Application for a Non-Material Amendment Following a Grant of Planning Permission

Erection of rear first floor extension to dwelling and erection of replacement garage with first floor annex

20/04734/FUL

Small changes to the garage windows and doors and moving the proposed garage building back so it is in line with the two storey building next door.

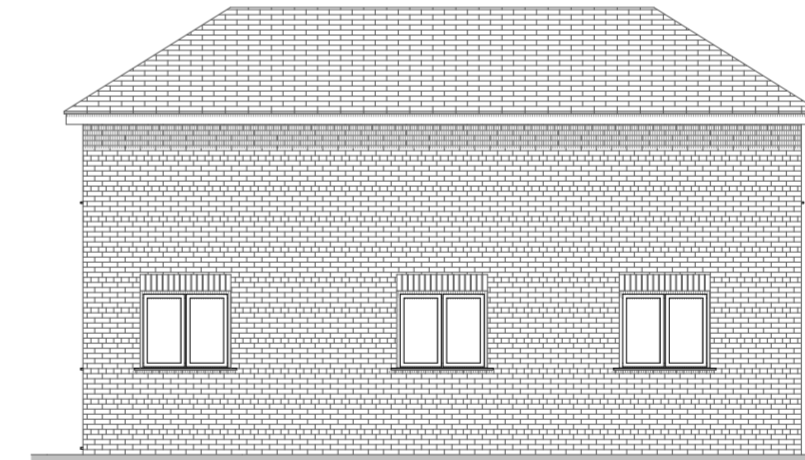
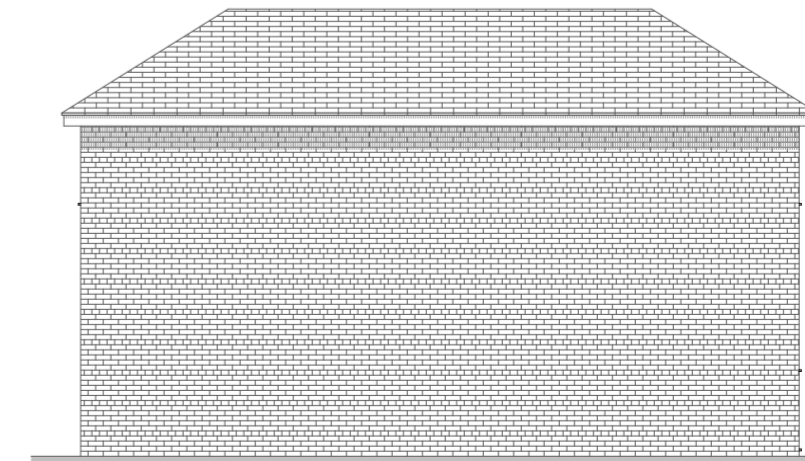
The proposed garage has also been reduced in width from 4.5m to 3.9m.
